## About the application

Application number: 2025/93140	
What is the application for?:	Installation of replacement shop front and roller shutter (within a Conservation
Address of the site or building:	Kami Healthcare Ltd, 8, Market Place, Birstall, Batley, WF17 9EL
Postcode:	WF17 9EL

## User comments

Proposed Front Elevation with Roller Shutter

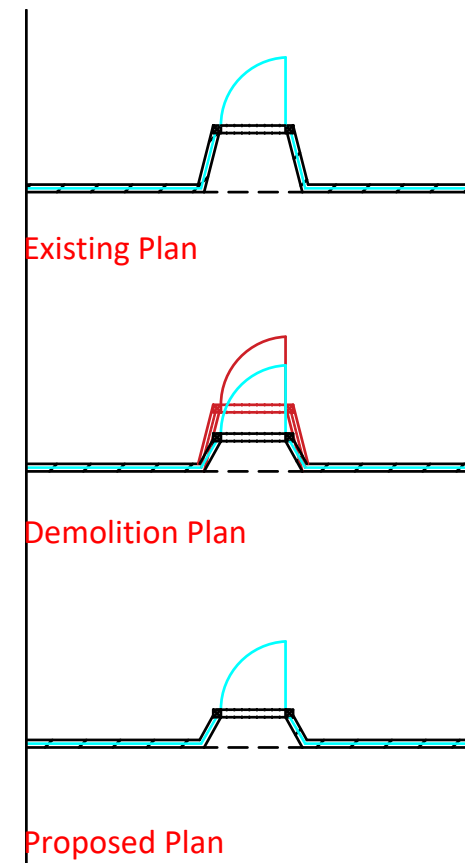
Type of comment: An objection	
Do you wish your comments to be published on the website anonymously?	<input type="checkbox"/> Yes
<p>As part of a conservation area a modern roller shutter would be totaly out of characyer to the village centre. Part renovations to the shop frontage have already destroyed mamy original features before the owners were forced to stop.</p> <p>Also the property is intending on using the premises as abbarbers. The village already has a high numbe of barbers, some of which seem to be used very little, bringing in little trade to the village and community.</p>
